DECISION DELEGATED TO DEVELOPMENT MANAGER

Application No:	H05-0326-20	Applicant:	Gem-Mix Holdings Ltd
Proposal:	Erection of 3 pairs of semi detached 3 bed dwellings along with up graded site entrance and road way, car parking and bin storage - re-submission of H05-0572-19		
Location:	37 Fleet Road Fleet Spalding		
Terminal Date:	12th July 2020

CASE OFFICER ASSESSMENT

DRAWING TITLE:
PROPOSED SEMI DETACHED 3 BED
PLANS AND ELEVATIONS PLOTS 1 & 2

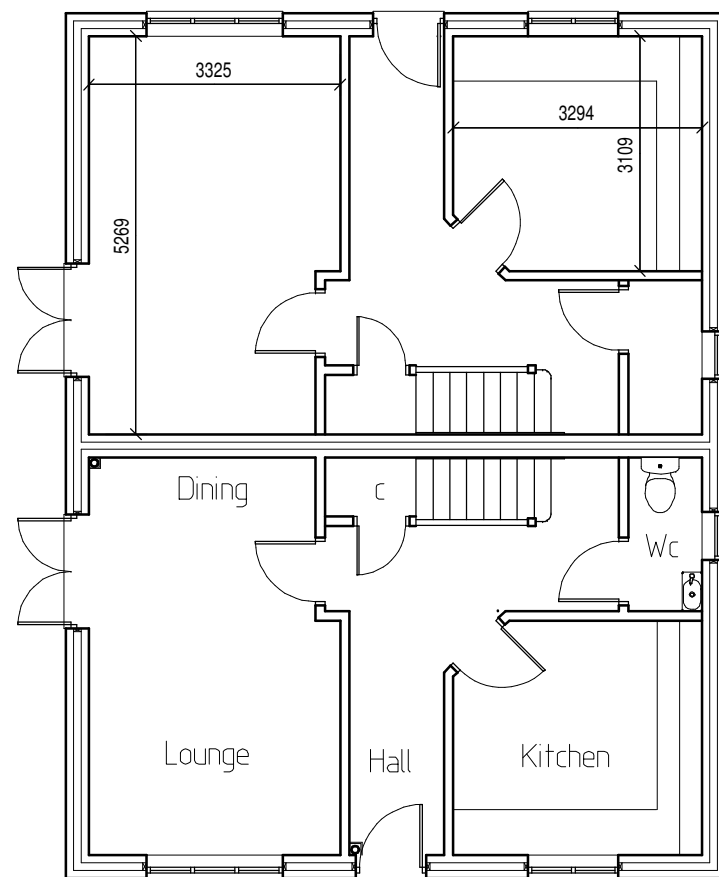
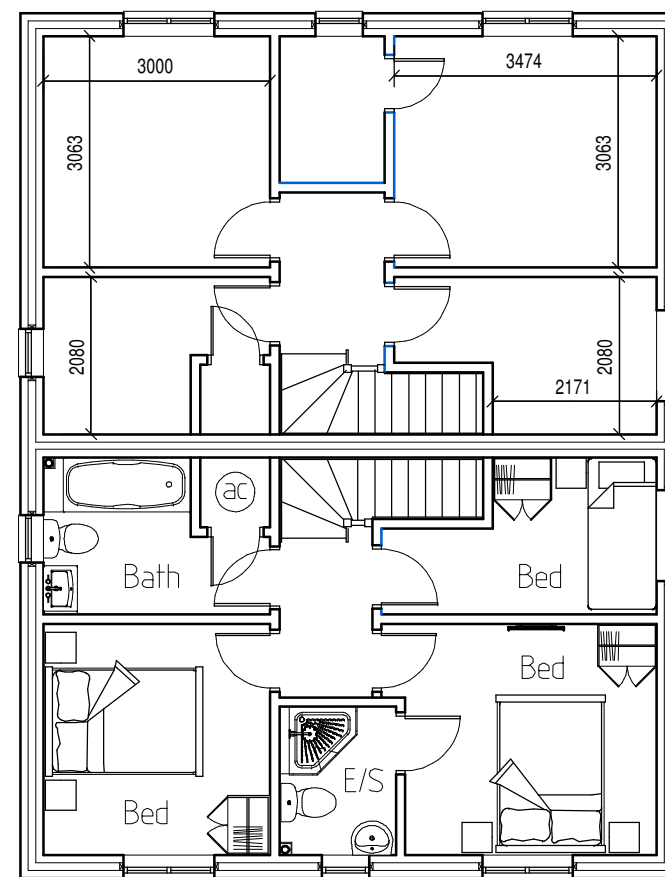
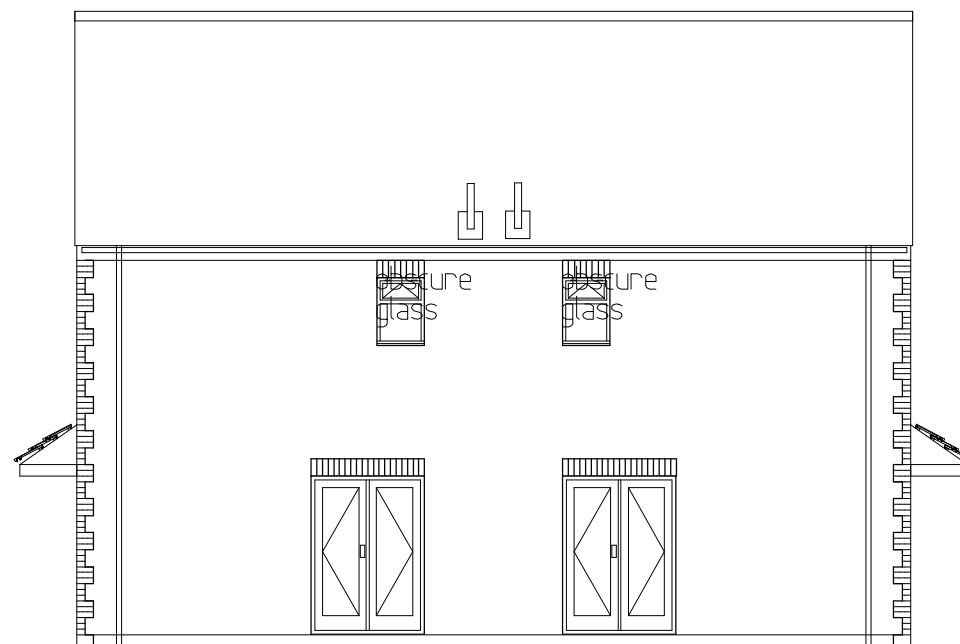
As a result of repositioning Plots 1 and 2 two metres closer to the western boundary, the separation distances will be also increased between the first-floor front windows and the rear garden of the property on Grimwood Close as well as first floor windows on opposing elevation.

Yet, the angle from the front bedroom windows to the centre of the back gardens is still such that it is considered that the proposal would cause still further loss of privacy for the existing neighbours when enjoying their outdoor amenity area.

The proposed floor plans of the semi-detached houses show 3 no. bedrooms on the first floor comprising 2 no. double bedrooms and one single bedroom. The latter would amount to 5.96 sq metres in the houses of Plots 1 and 2, and 6.39 sq metres in the houses of Plots 3, 4, 5 and 6. These dimensions would be far distant from the minimum required for single bedrooms, which is 7.5 sq metres. For these reasons, the gross internal floor area would be insufficient to ensure good amenity standards to the future occupiers.

DRAWING TITLE:
PROPOSED SEMI DETACHED 3 BED
PLANS AND ELEVATIONS PLOTS
3-4-5-6

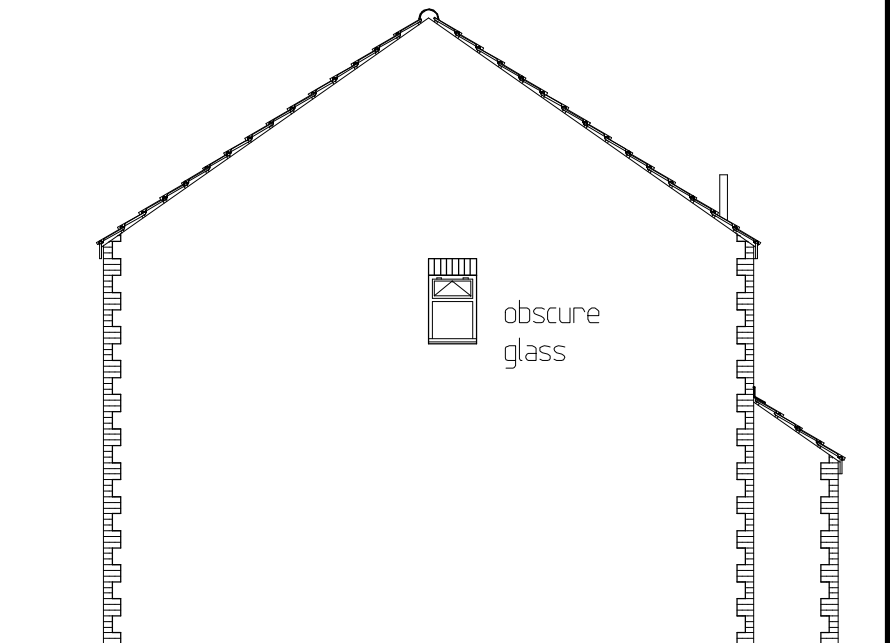
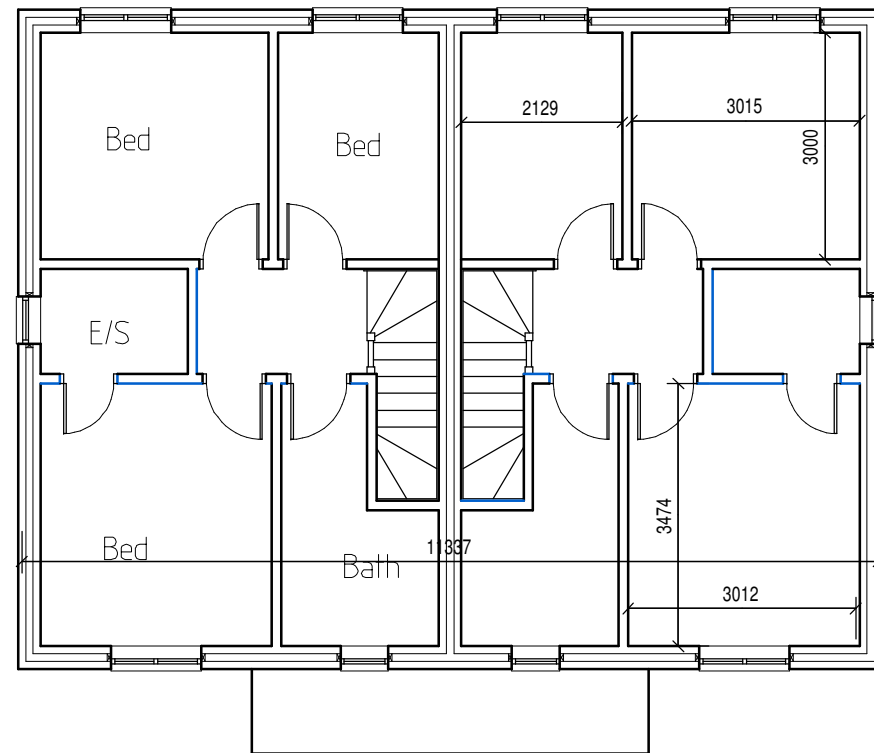
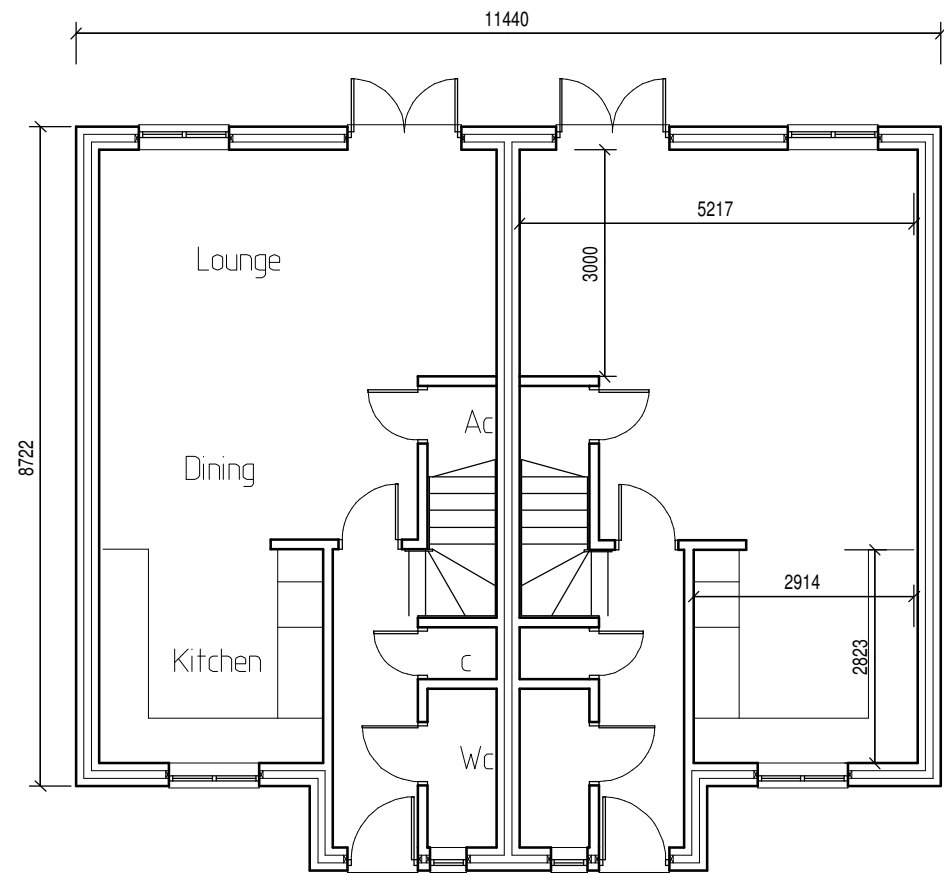
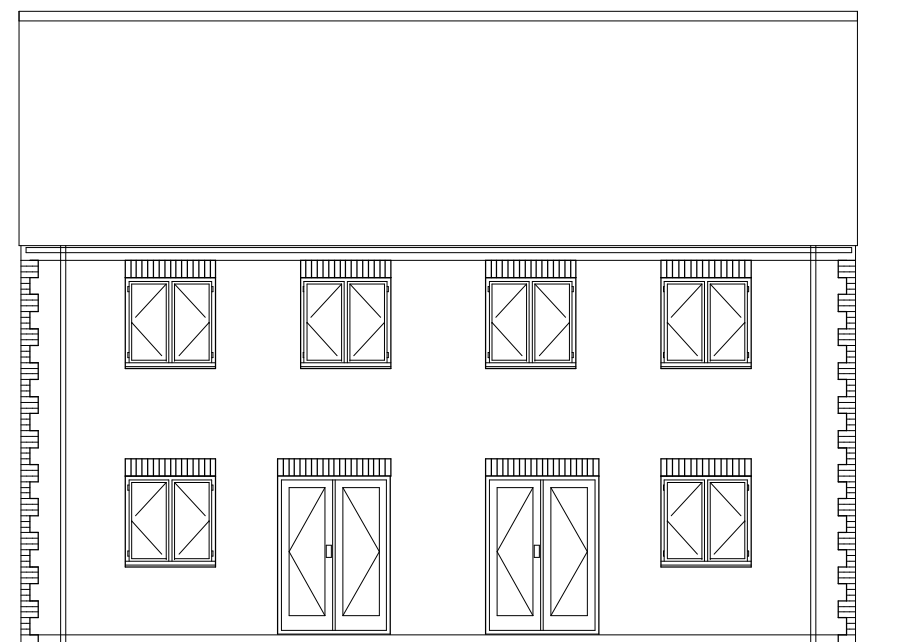
Another issue of amenity is the overbearing impact of the houses in Plots 5 and 6 upon the residents of the neighbouring properties to the east (Grimwood Close). The footprint of the above-mentioned dwellings will appear merely 1.12 metre set back from the eastern boundary of the site. The nearest properties to the proposed houses is No. 11 and 12 Grimwood Close. On balance, the maximum height of 8.40 metres of the proposed houses will appear excessive given the separation distance of 10.65 metres with the nearest existing properties.

DRAWING TITLE:
PROPOSED NEW SITE
LAYOUT

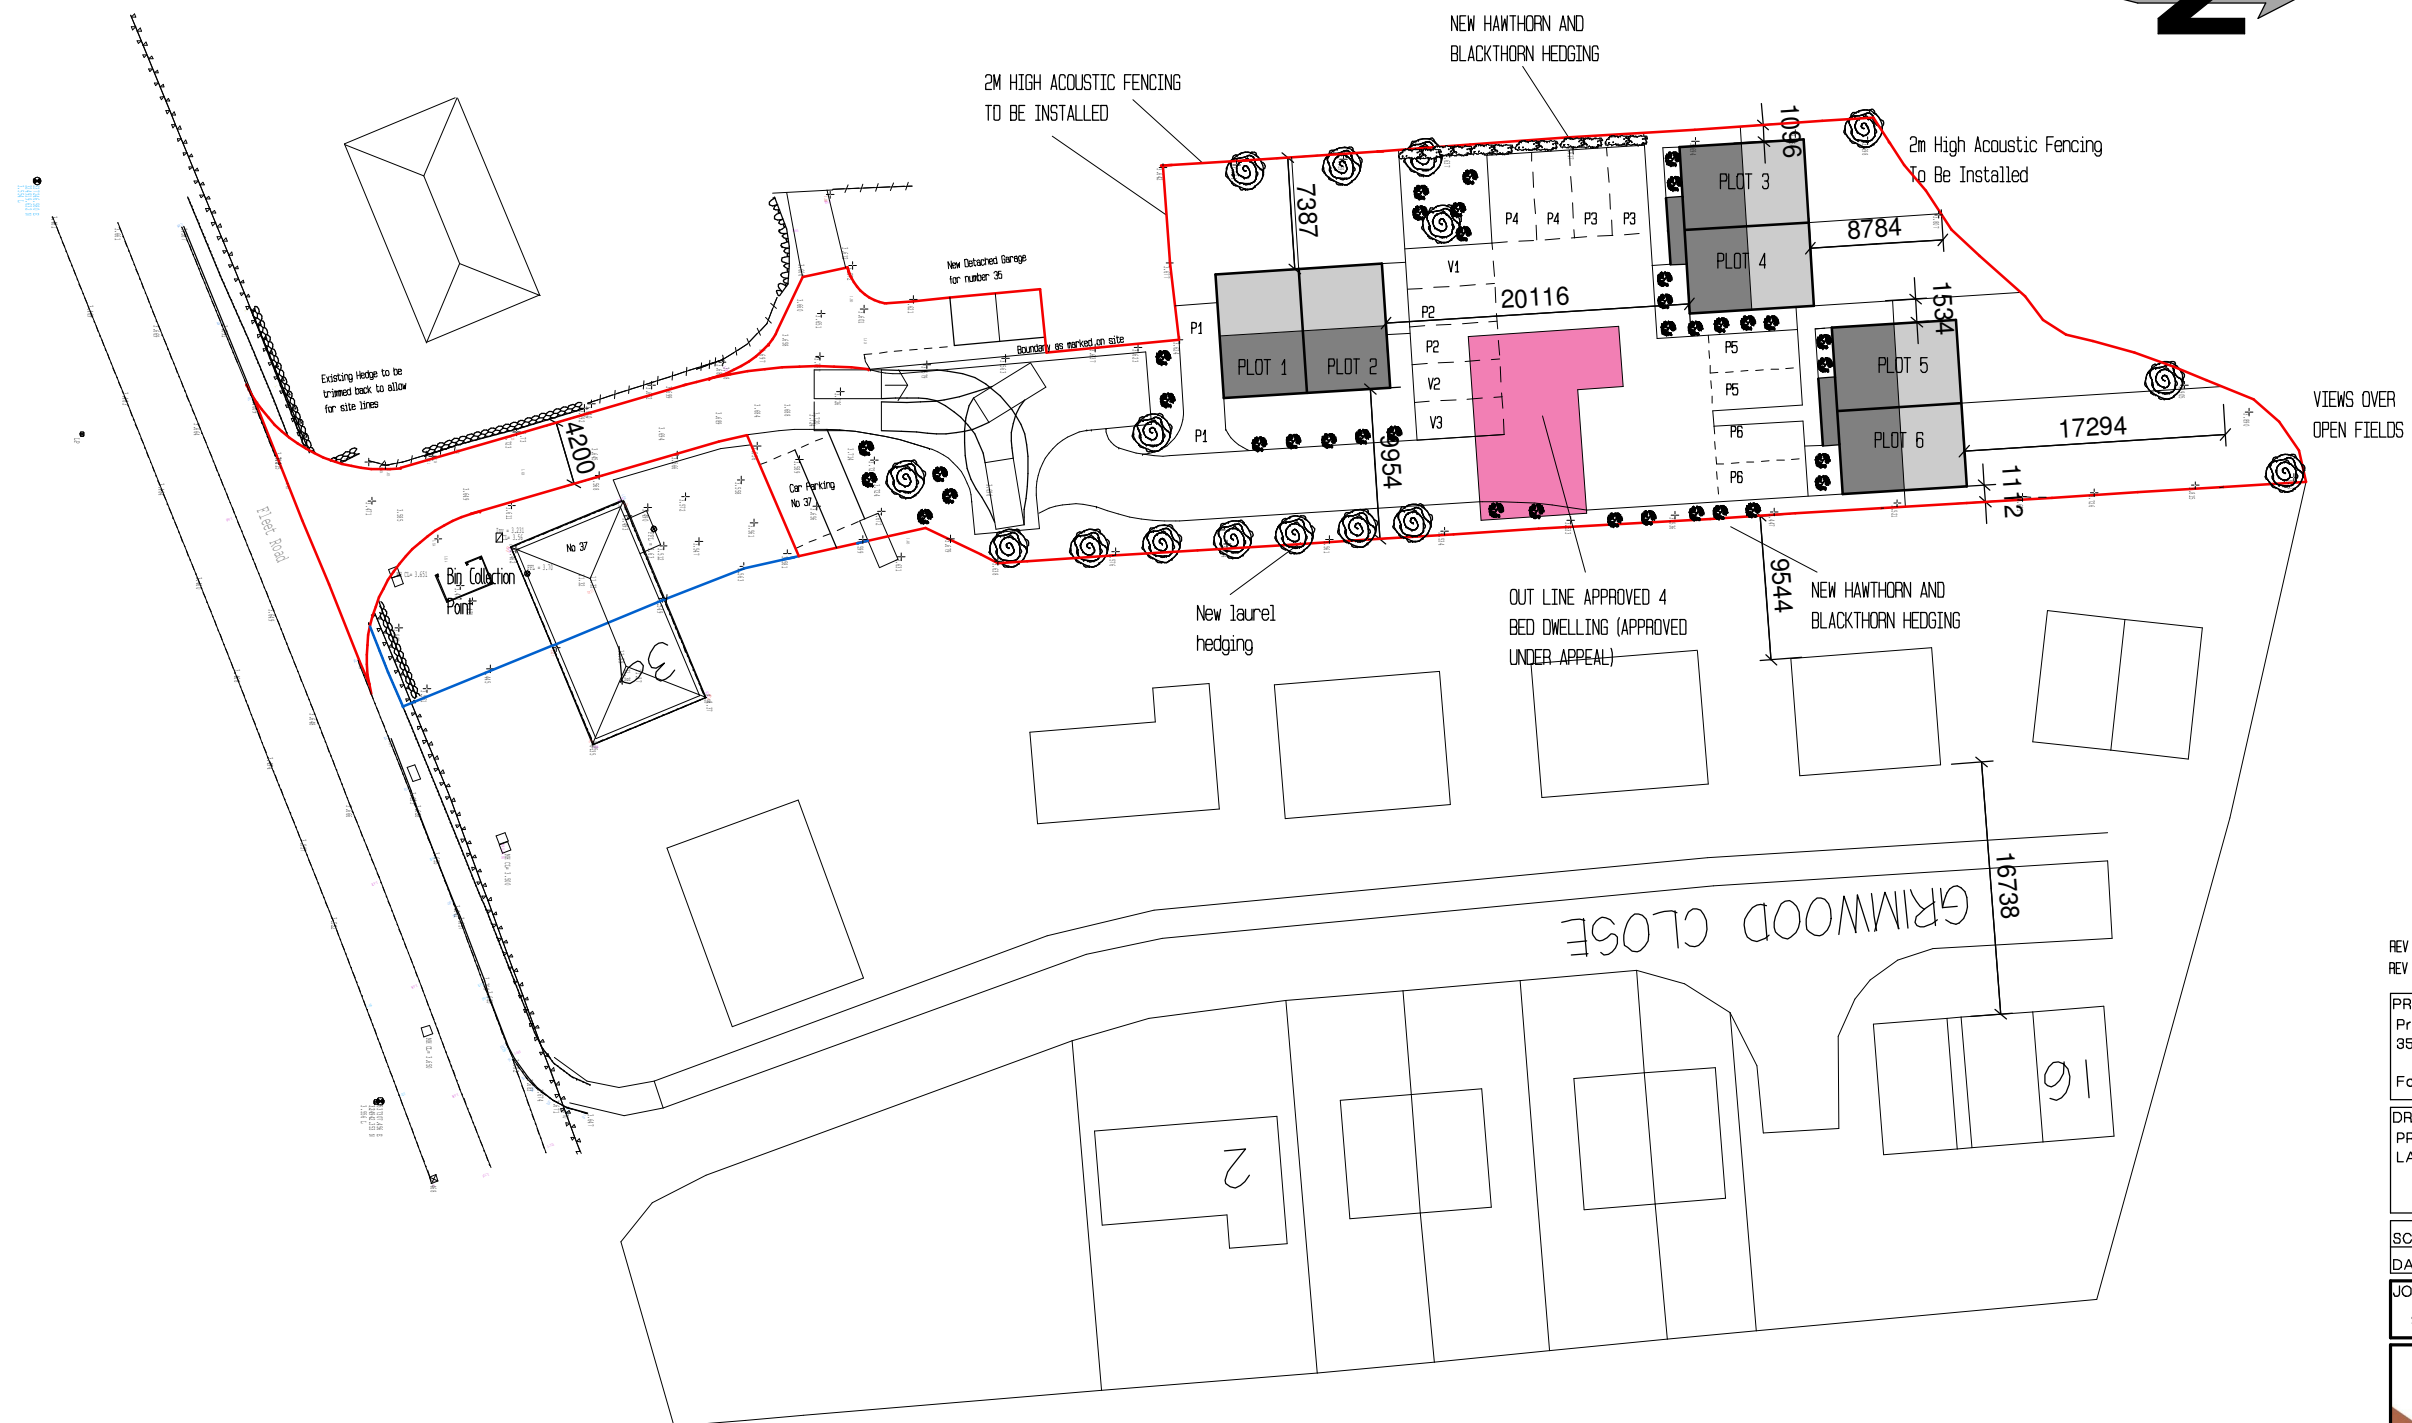
Whilst it was acknowledged that the position and footprint of previous dwellings delivered a form of development nearly mirroring the row of houses in Grimwood Close, the proposed site layout this time provide somewhat variety in relation to the established pattern in the surroundings. The first pair of semi-detached will be near the turning point facing Grimwood Close (east). The other two pairs will be in close proximity to the eastern and western boundaries of the application site, both facing Fleet Road (south).

The roadway layout have been also altered in comparison with the previous application. The end of the private roadway is now at the centre of the main bulk of the site. Car parking spaces will be provided between the elevations of the dwellings and the edge of the end of roadway. The adequacy of highway specifications and parking provision is detailed in a separate section below.

The separation of these facilities is in the region of 7.60 metres with the nearest boundary of the proposed site for the residential scheme. In addition to that, the distances of the nearest dwellings with such boundary range between 7.38 metres and 1.09 metre. Therefore, most of the scheme will be in close proximity to a potential source of noise pollution.

Following the newly proposed site layout, the levels of noise pollution will clearly impact further the amenity of the residents than in the previous proposal. All plots were set back 9 metres from the boundary adjoining the industrial site. With this application, Plots 1 and 2 will be around 2 metres closer to such boundary up to 7 metres. Plot 4 will be separated 6.60 metres and Plot 3, merely 1.09 metre. As a result of that, the habitable spaces of the houses in Plot 3 and 4 will be also closer than those in Plot 5 and 6 of the previous scheme.

The appeal was allowed on the basis that the site would not be developed towards the rear of No. 37 Fleet Road. However, the proposed development will clearly entail the population of four further dwellings across the entire site and consequently the open space will cease to exist and significant harm will occur to the residents of houses in Grimwood Close by reason of overbearing impact, especially Plots 5 & 6.
